April 17, 2024

Re: Kendall Auto Group Auto Storage Yard – *Technical Review 3*
PA 23020

City of Marysville Community Development – Planning Division

City of Marysville Public Works – Engineering Services

SHEET 51

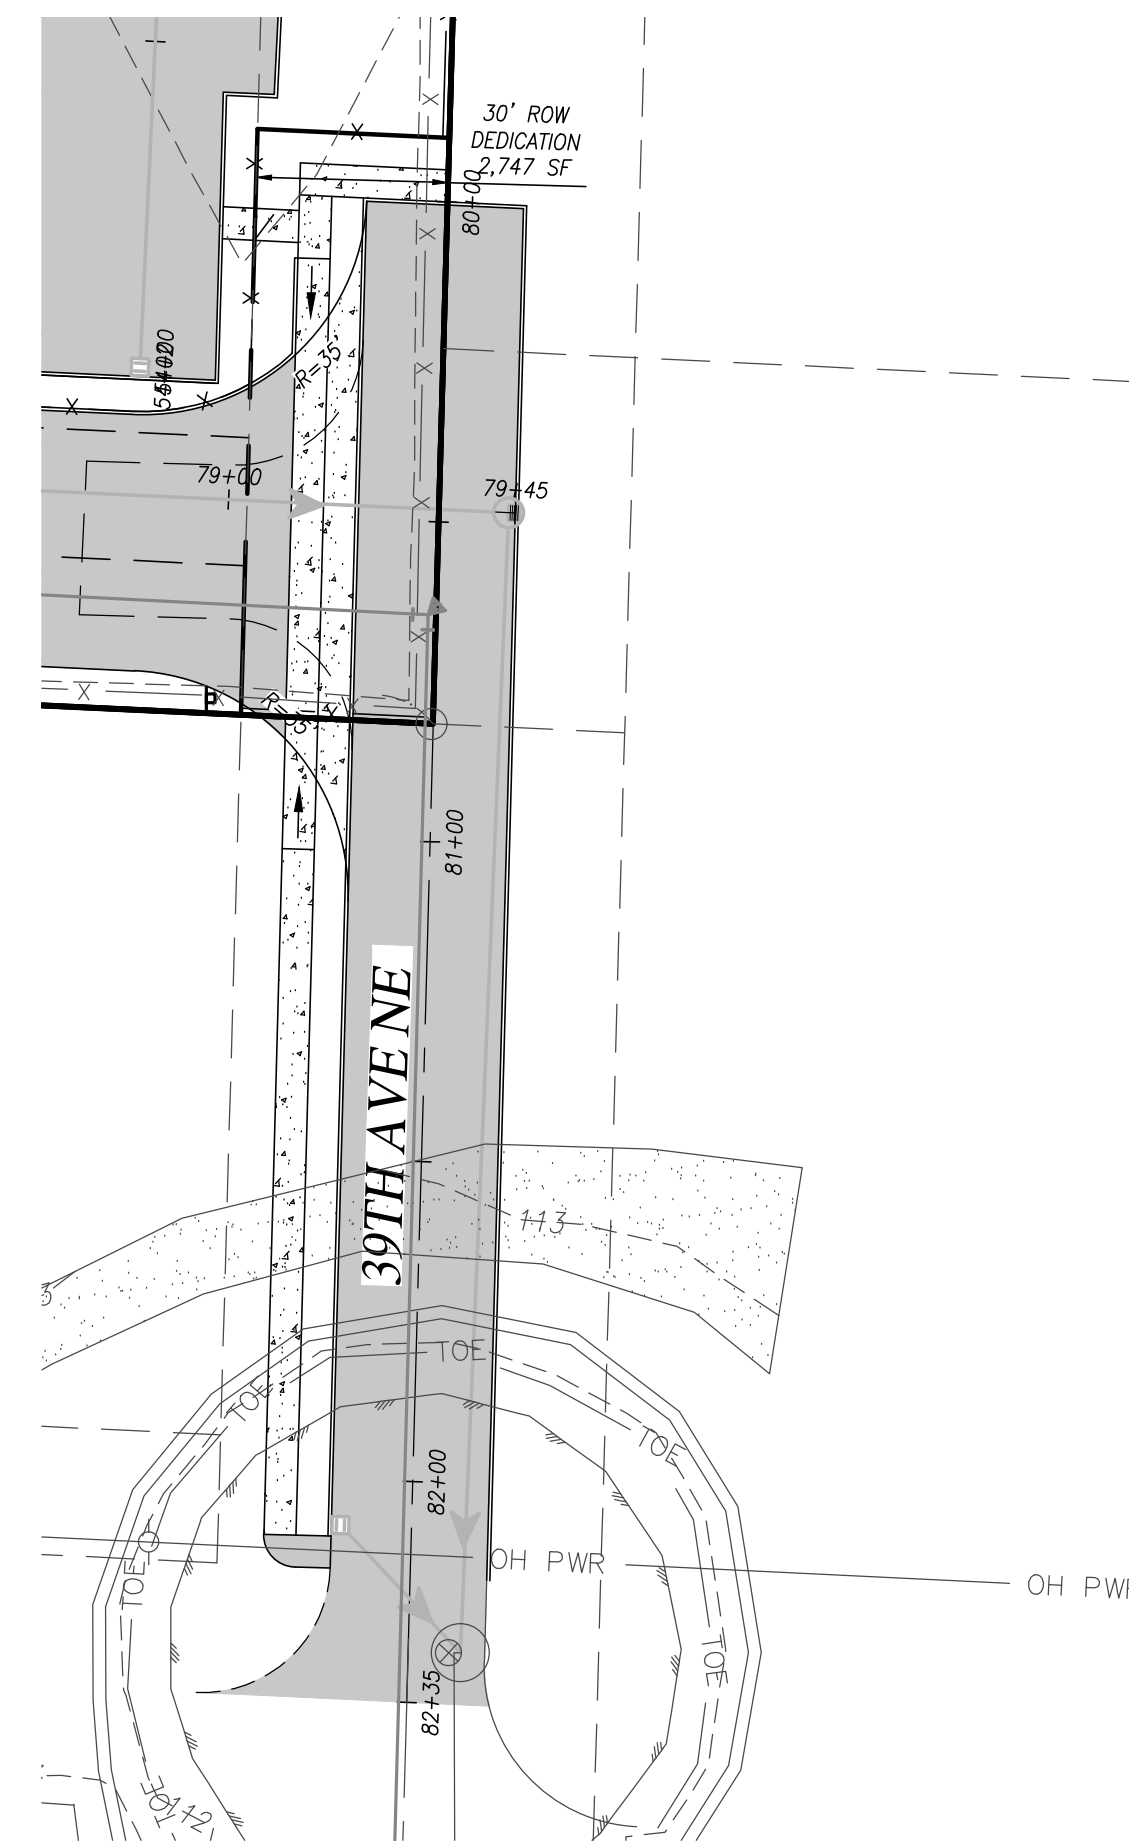
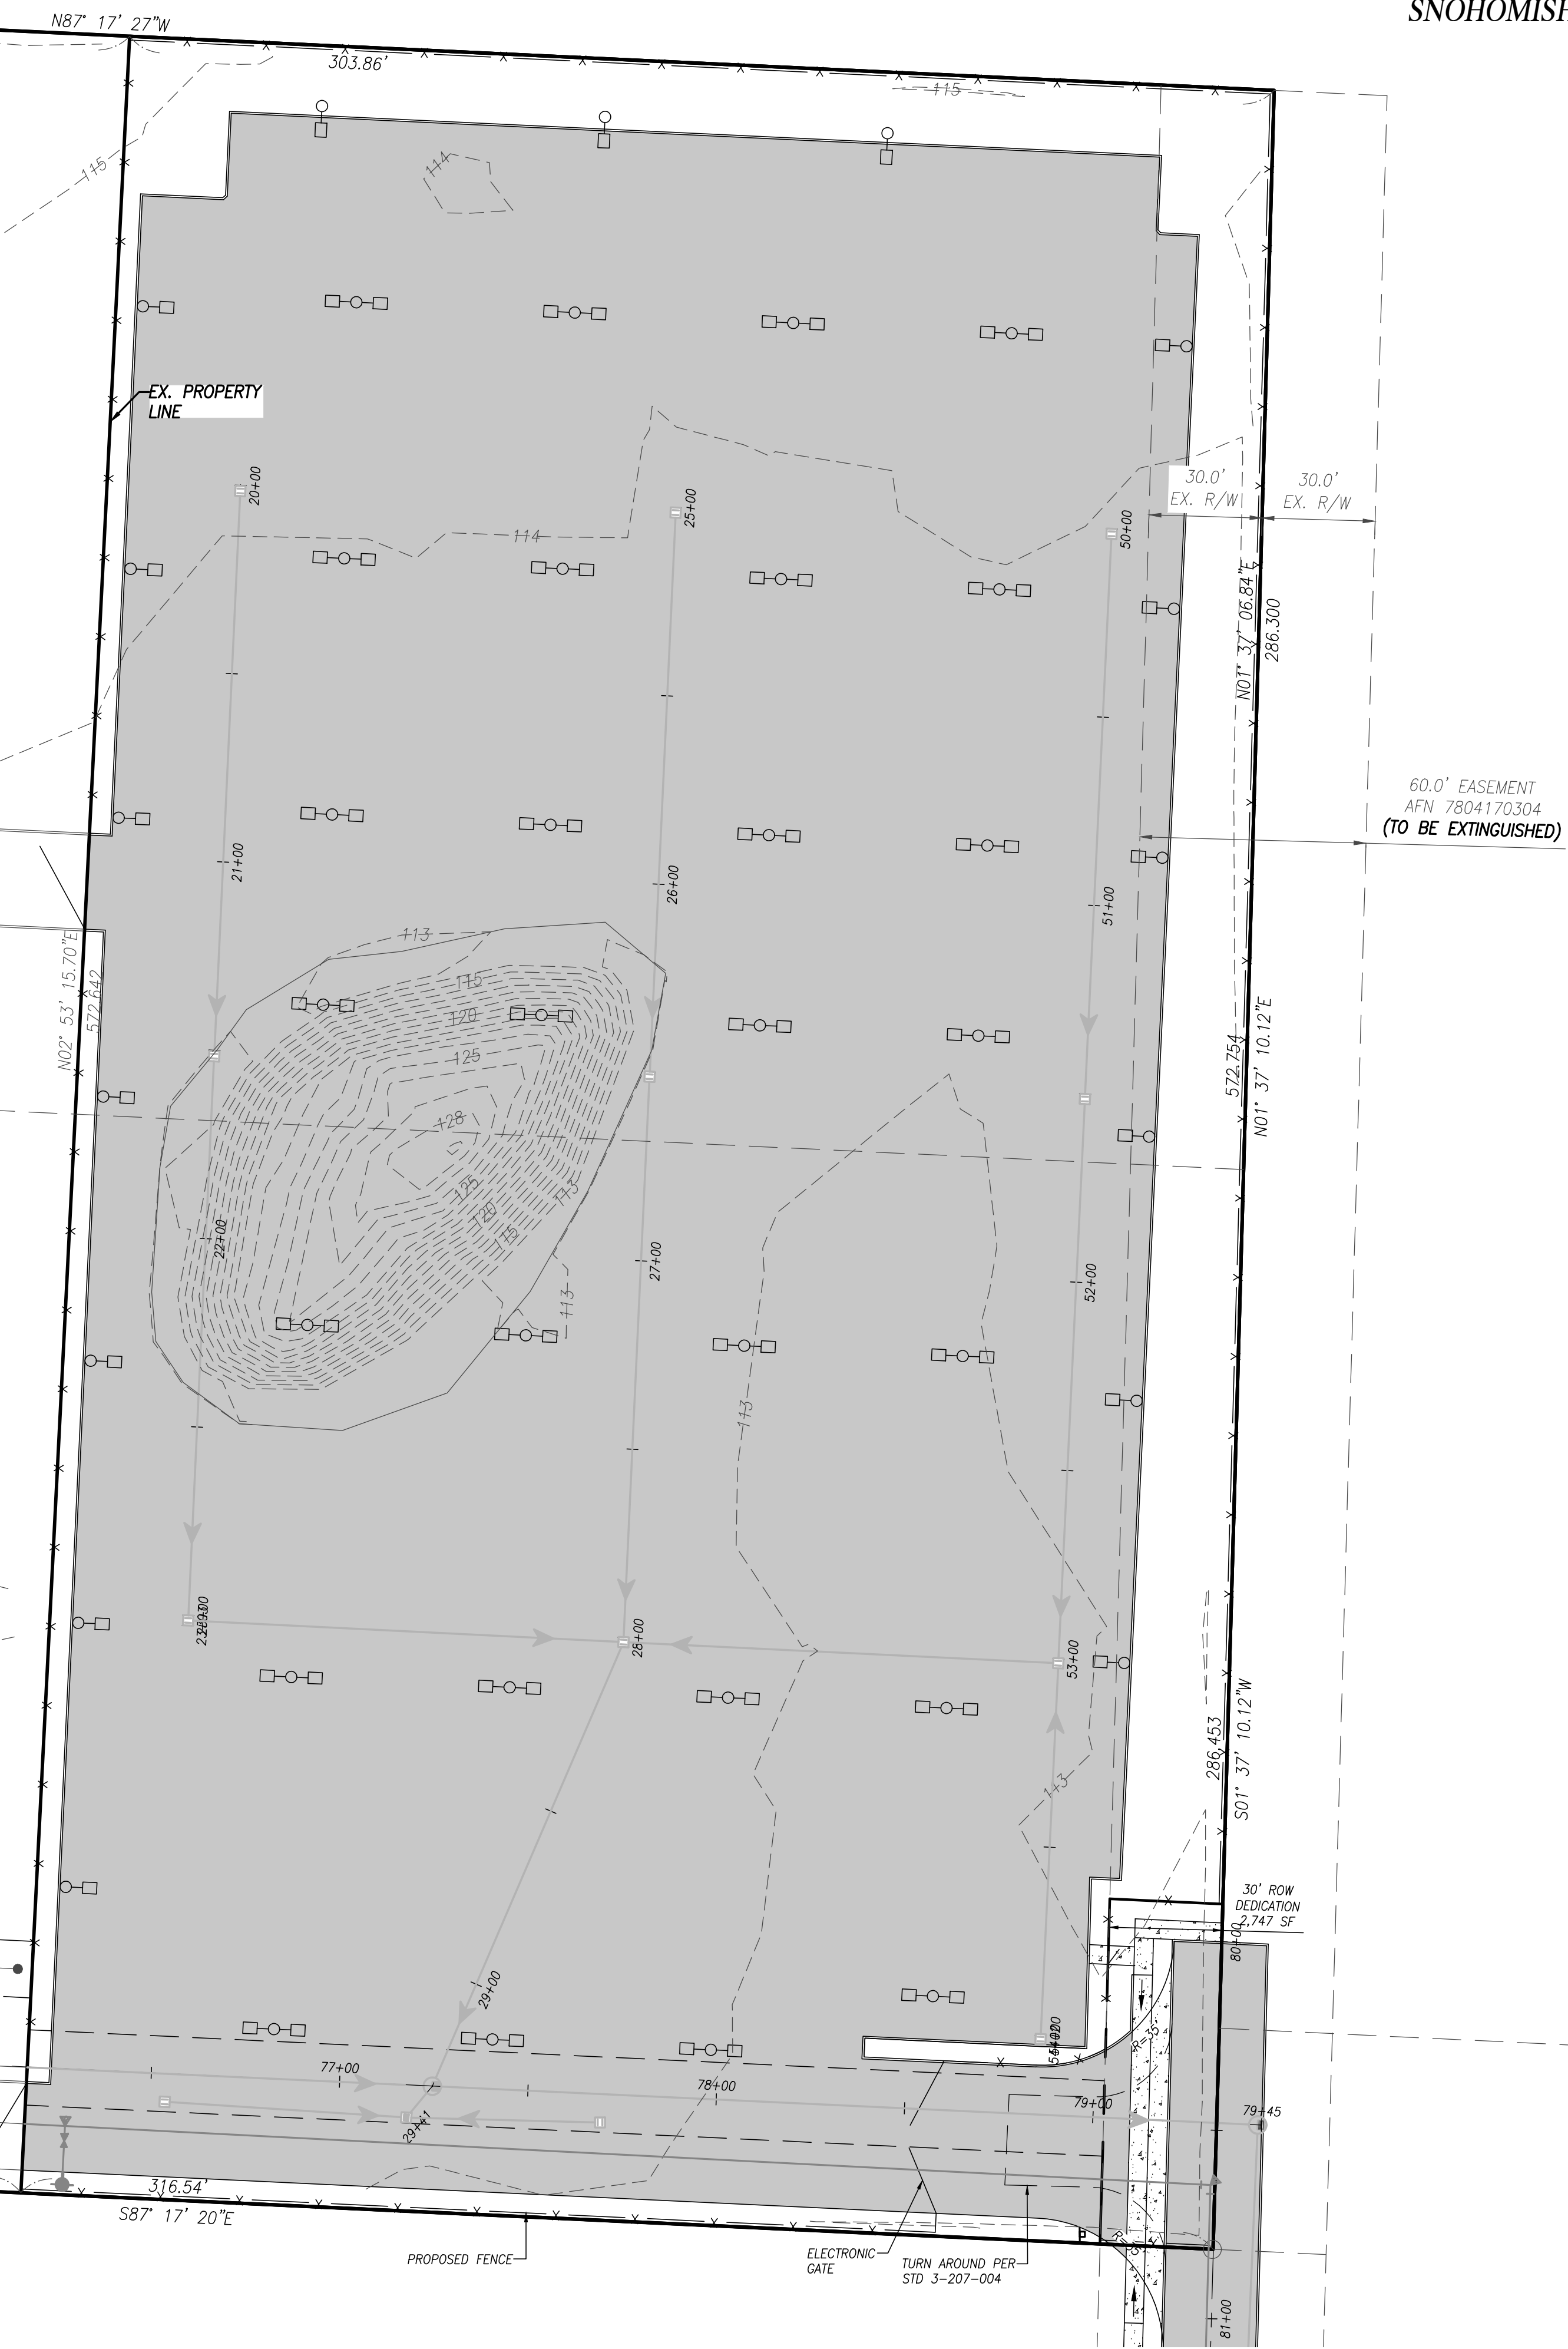
1. The landscape plan is approved, as submitted (E024).
2. The site plan will need to be amended per the comments below from Kacey Simon, Civil Plan Reviewer.

| HORIZONTAL CONTROL PLAN <b>C1.2</b>                                   |                  |

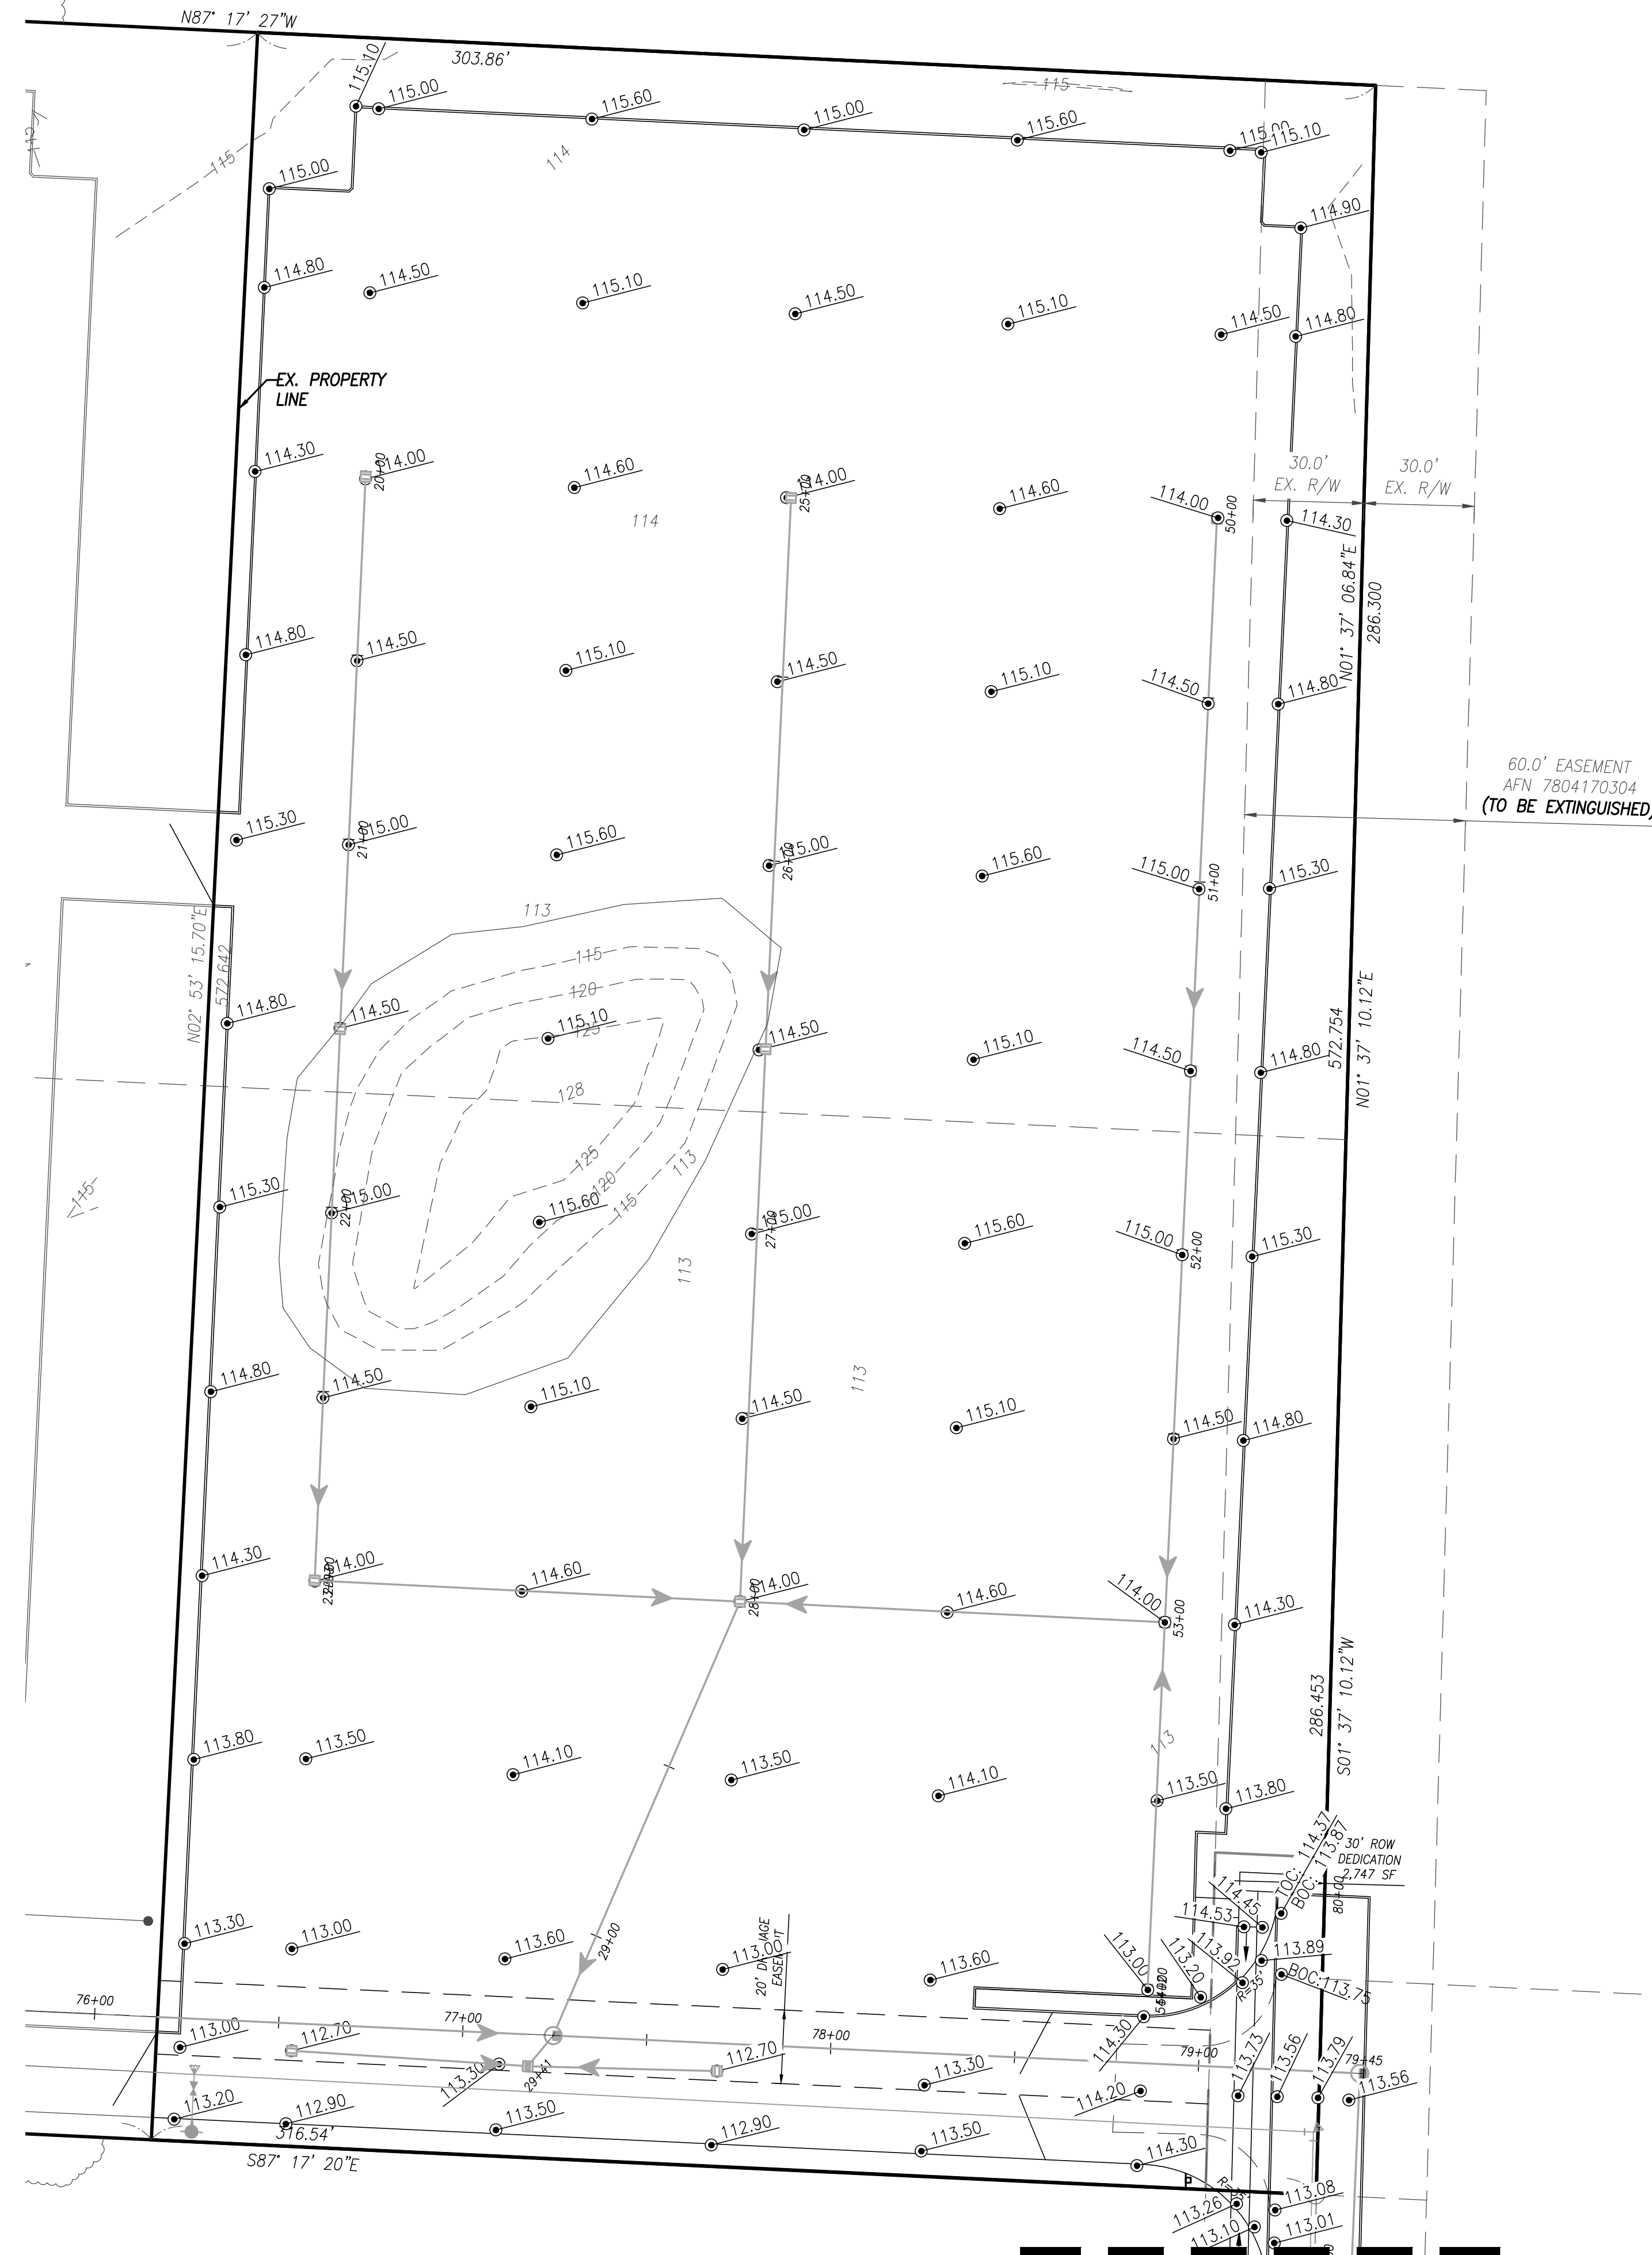
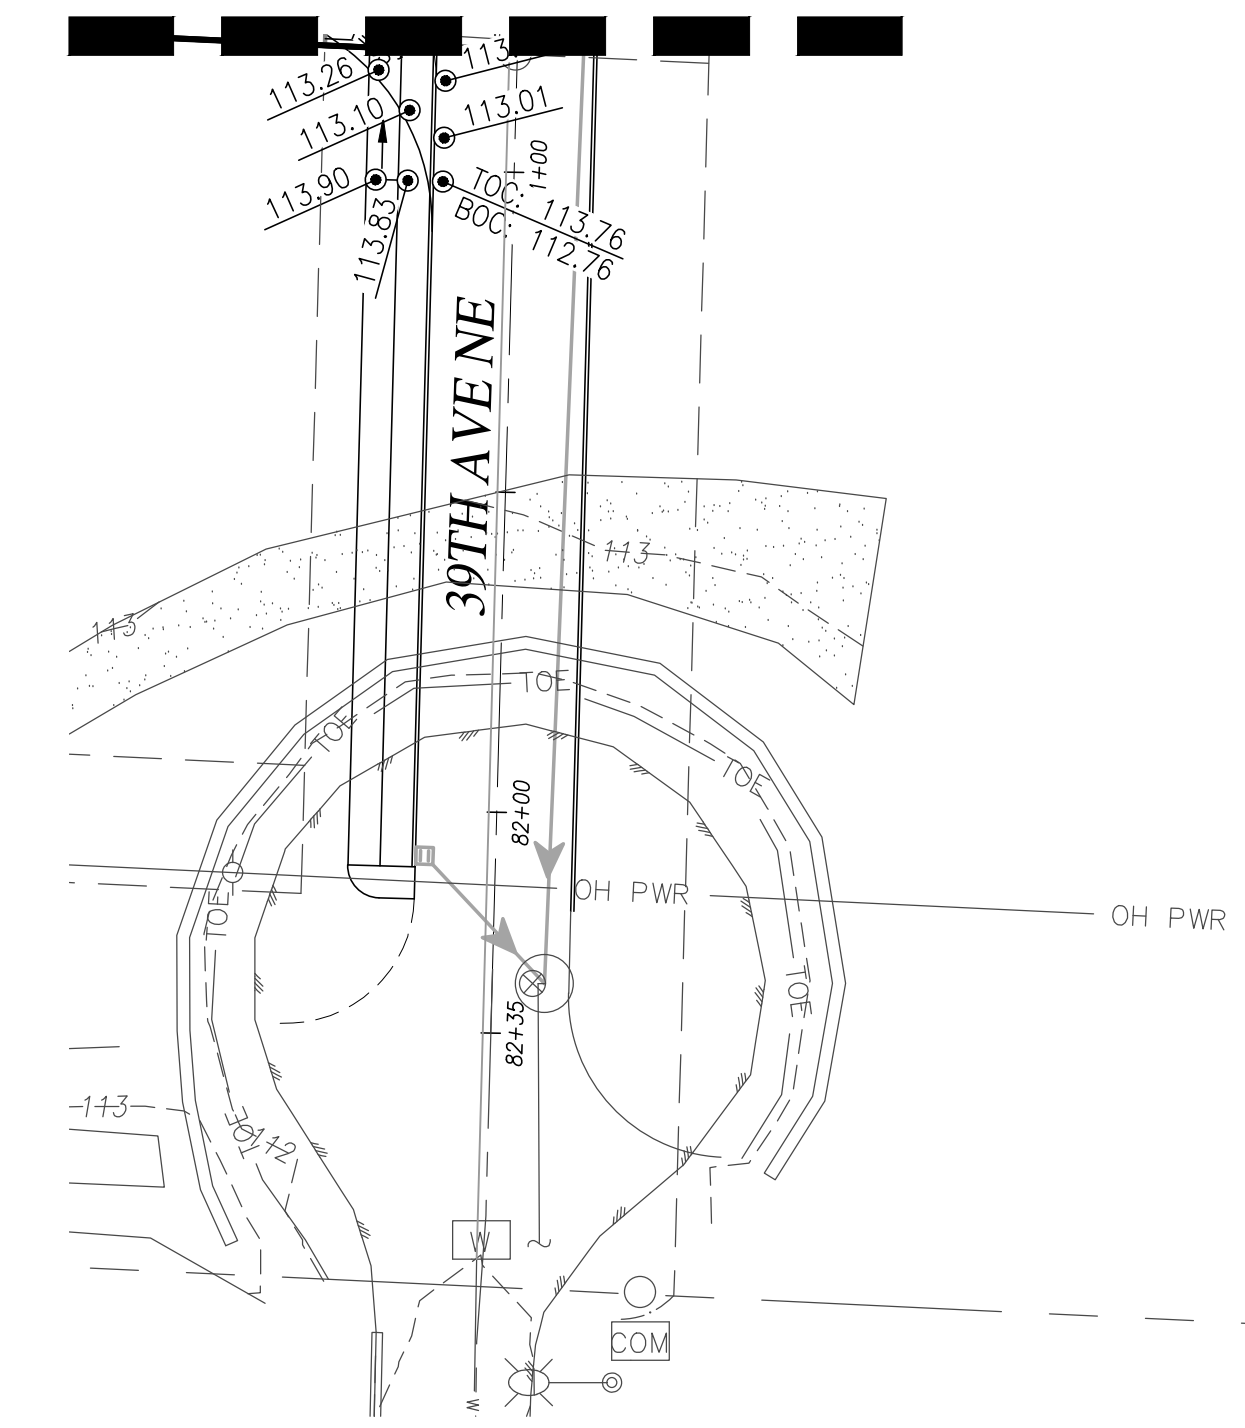
3. Access to the site may be provided via a private driveway north of the intersection of 160th Street NE and 39th Avenue NE. The private driveway shall include a hammerhead turn-around consistent with Marysville Standard Plan 3-207-004. If the site is intended to have a perimeter fence, the fence shall remain outside the limits of the required turnaround. If this parcel is redeveloped in the future, then additional improvements, including curb, gutter and sidewalk may be required.
4. Security lighting along the private drive will be required, as approved by the City Engineer.
